Application No: 20/03192/DISC

Proposal: Discharge of Condition 25 (Phasing), Condition 36 (Construction Management Plan), Condition 37 (Construction Environmental Management Plan for Biodiversity), Condition 38 (Tree Protection), Condition 39 (Training and Employment Plan) and Condition 45 (Site Access) and Partial Discharge of Condition 40 (Sustainable Drainage) and Condition 46 (Estate Roads, Parking and Turning Areas) of 19/01740/HYBRID

Location: Land Adj To Promised Land Farm, Wendlebury Road, Chesterton

Transport Development Control

Access Road Setting out 1:250

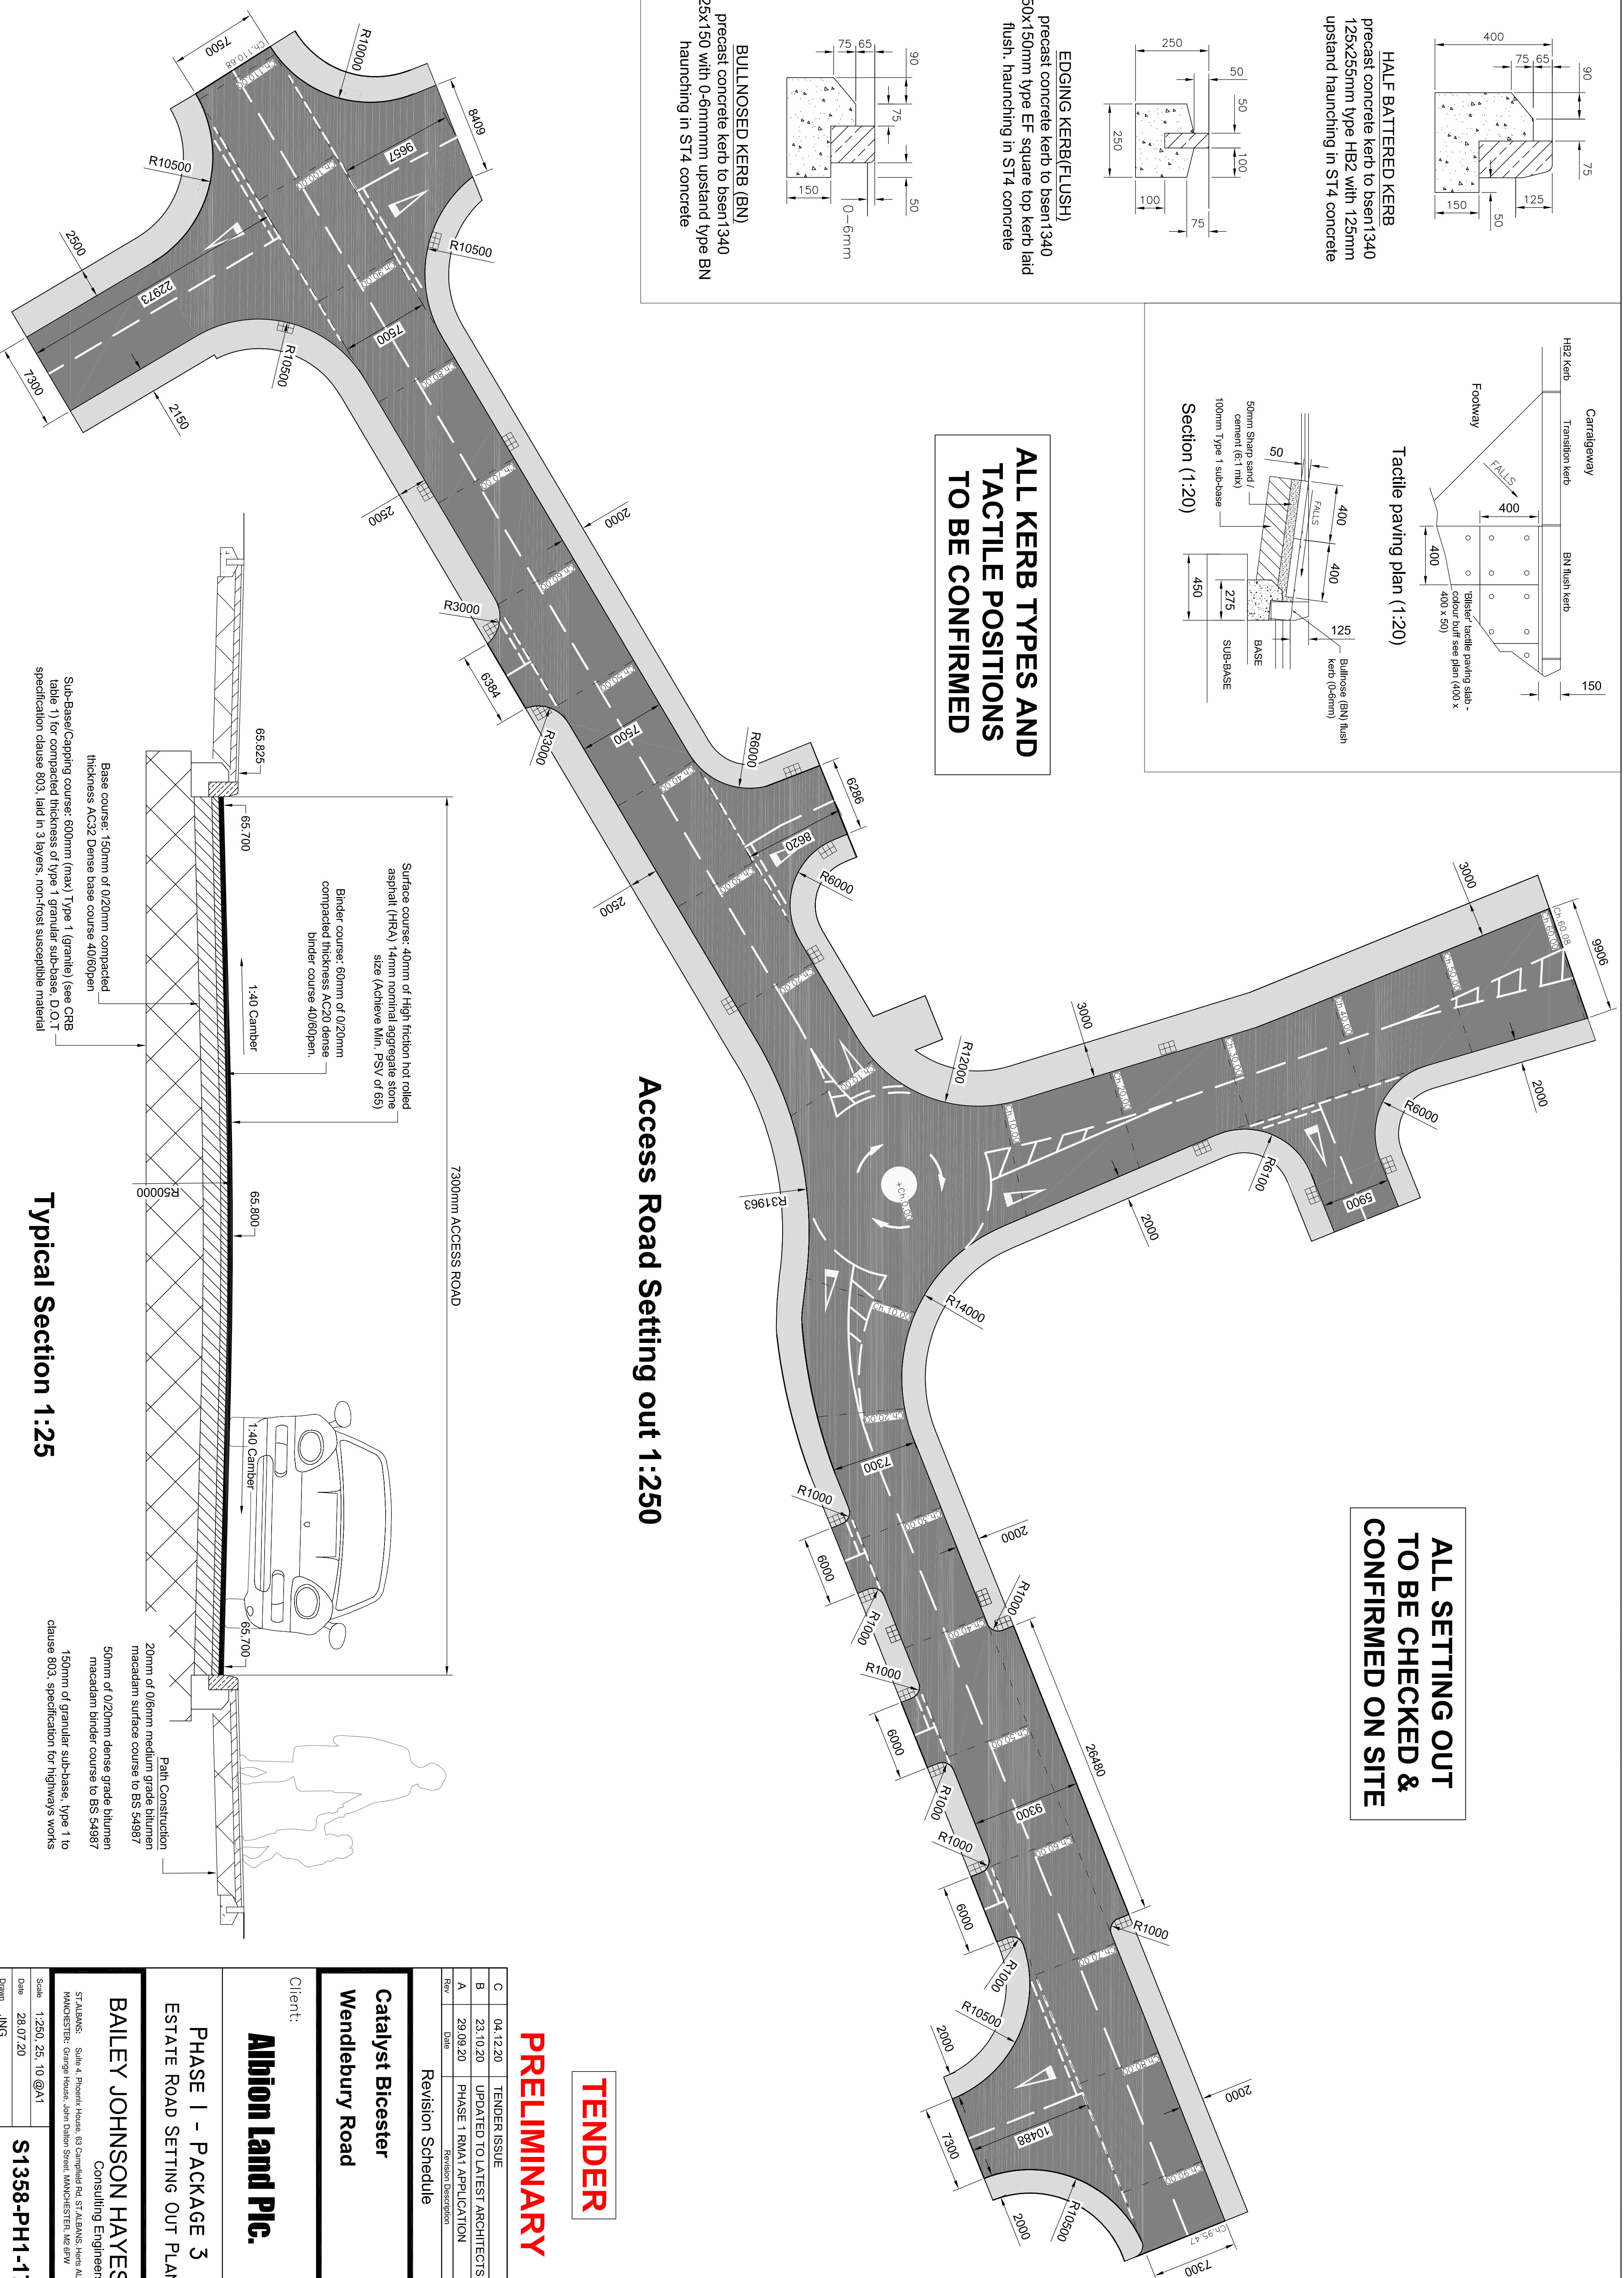
Similar to above, the estate roads need to provide for both pedestrians and cyclists including crossing points at junctions or side roads.

SECTION 278 WORKS  
THAMES WATER ACCESS &  
BICESTER AVENUE EXIT WORKS

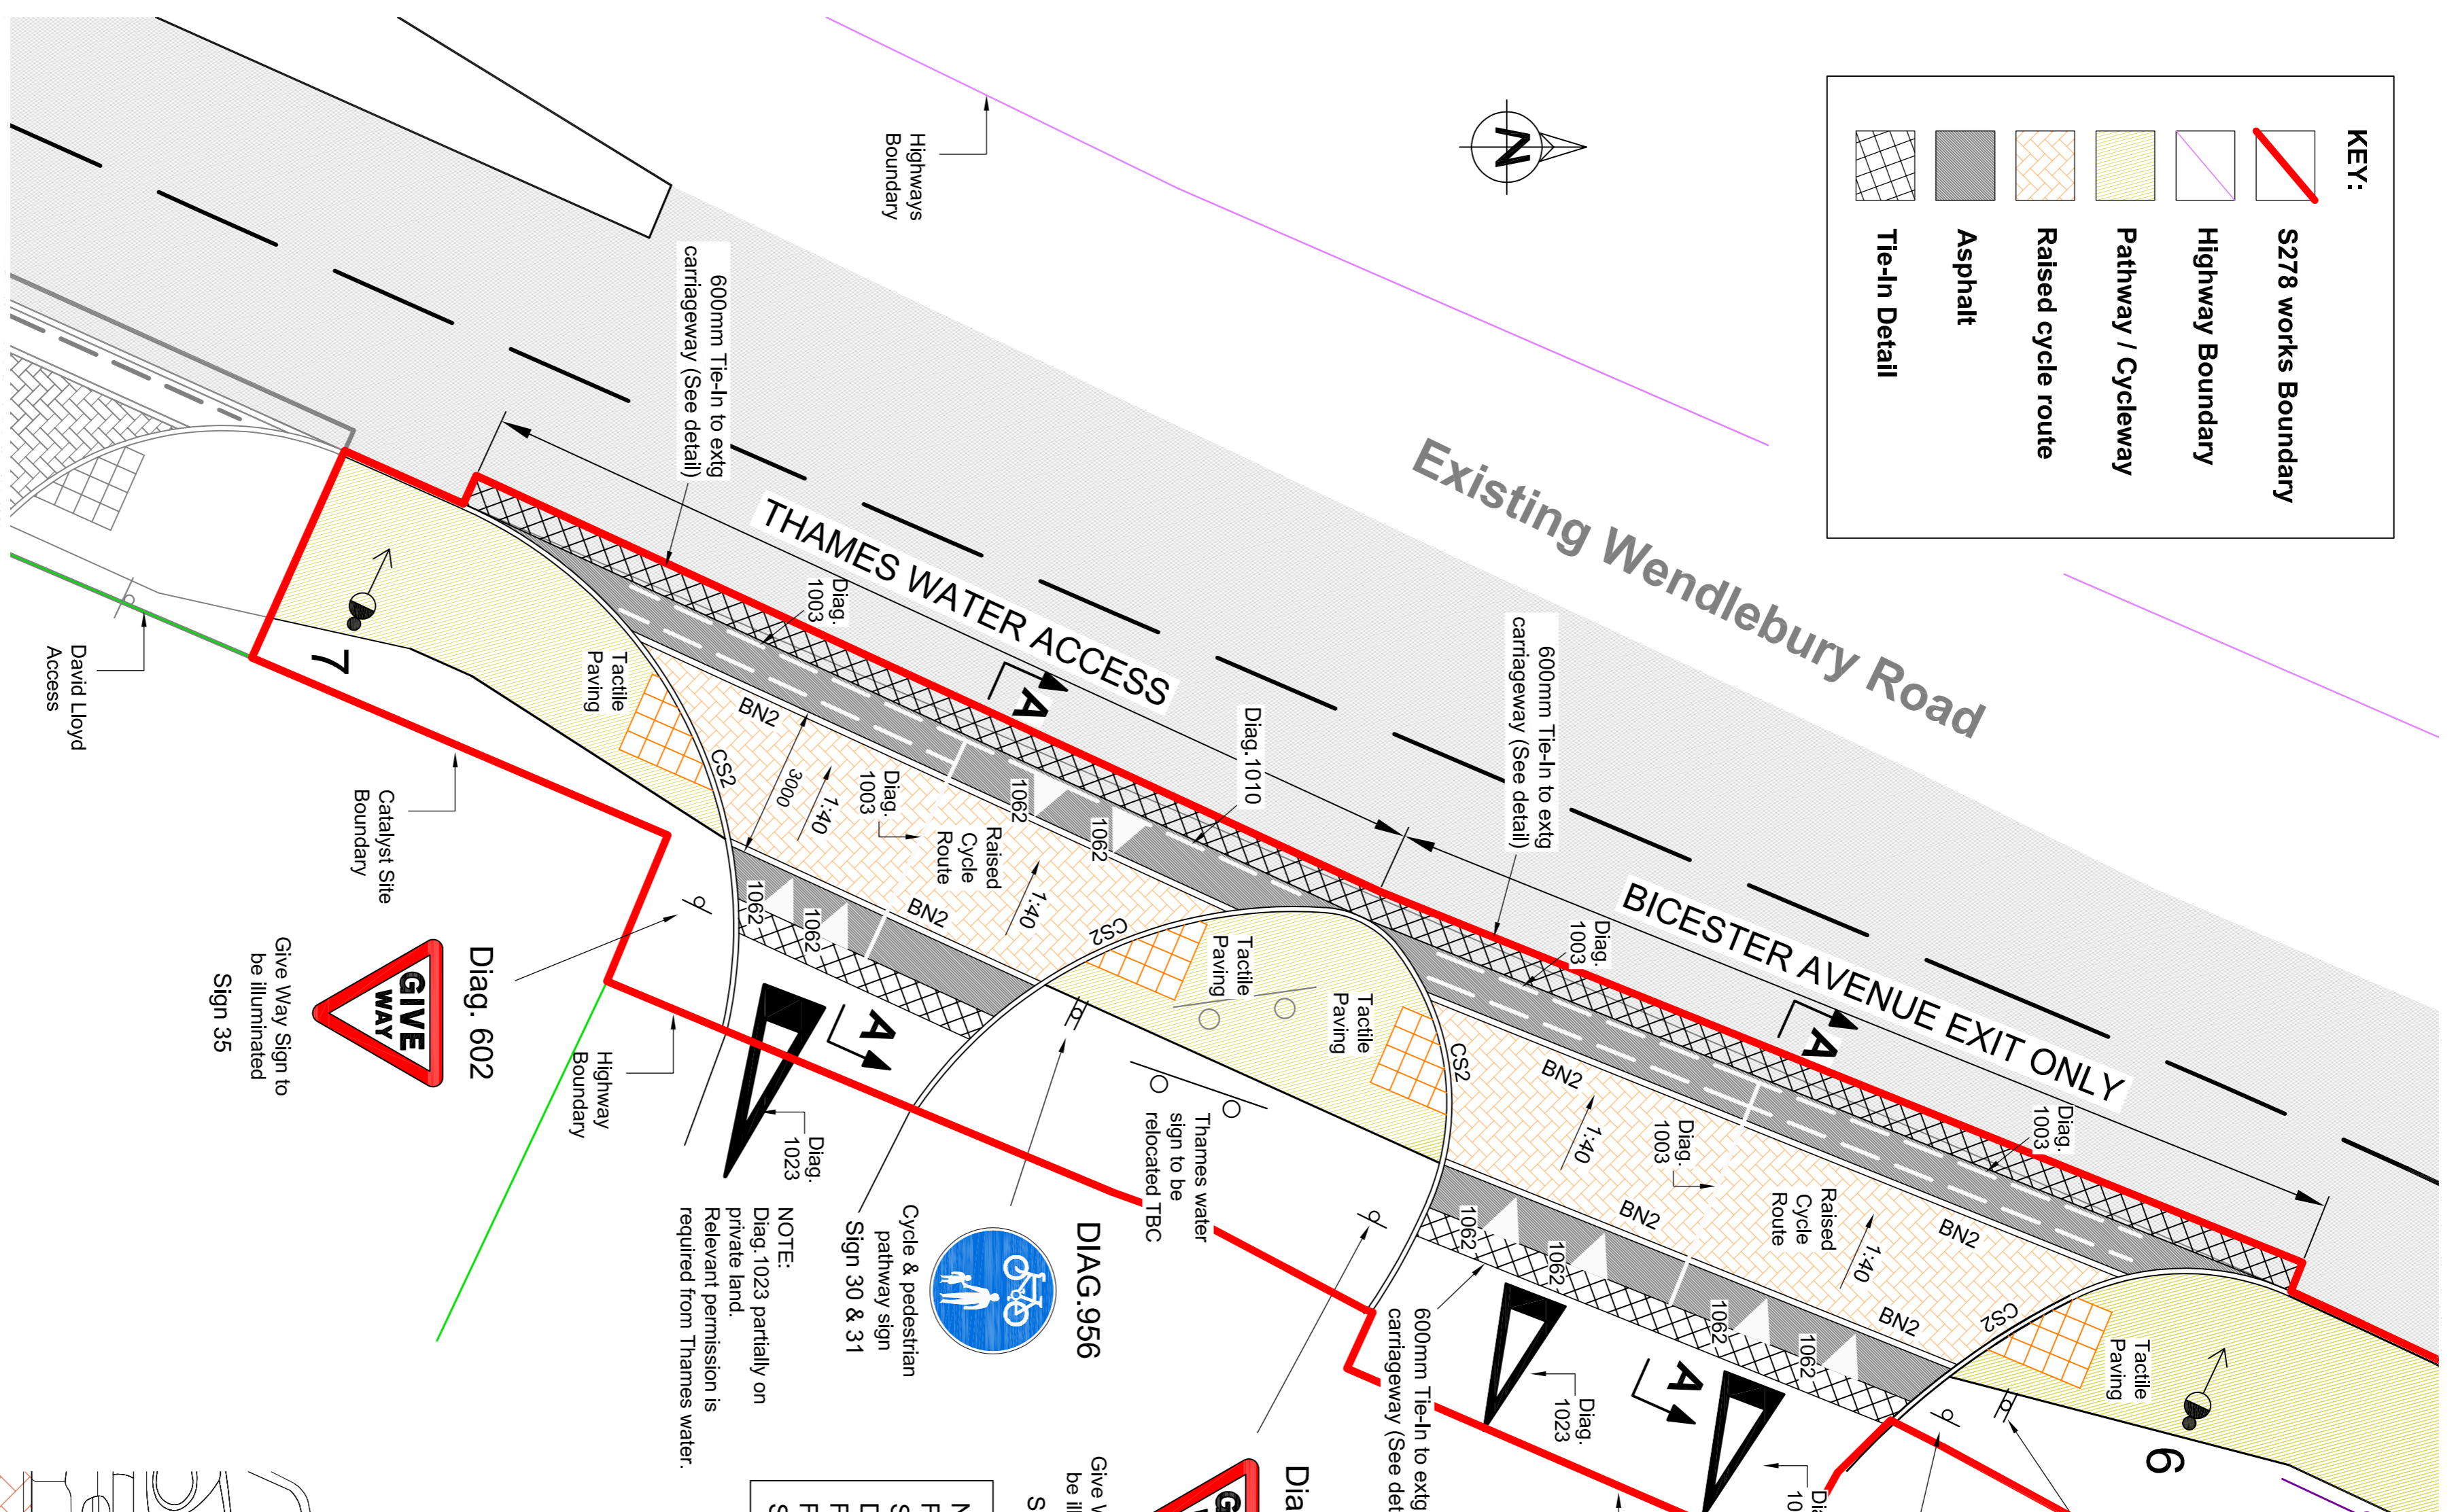
Access plans show the primary road to be flanked by a 3m shared footway/cycleway on the southern side while the northern side is a 2m footway. This arrangement is considered to only be satisfactory for vehicles and pedestrians but does not adequately cater for cyclists, requiring them to use indirect routes that are less convenient. It is seen that cyclists from Wendlebury Road (N) on a 3m shared facility would be in a limbo when the shared facility does not extend into the site, bringing confusion on how they would proceed into the development. It would be preferable to extend a similar width into the site that caters for both pedestrians and cyclists. Other than that, a cycle lane (advisory) needs to be introduced on the access road including an appropriate transition for them to merge onto the carriageway, like those proposed on the merge onto/from Wendlebury Road (S)carriageway.
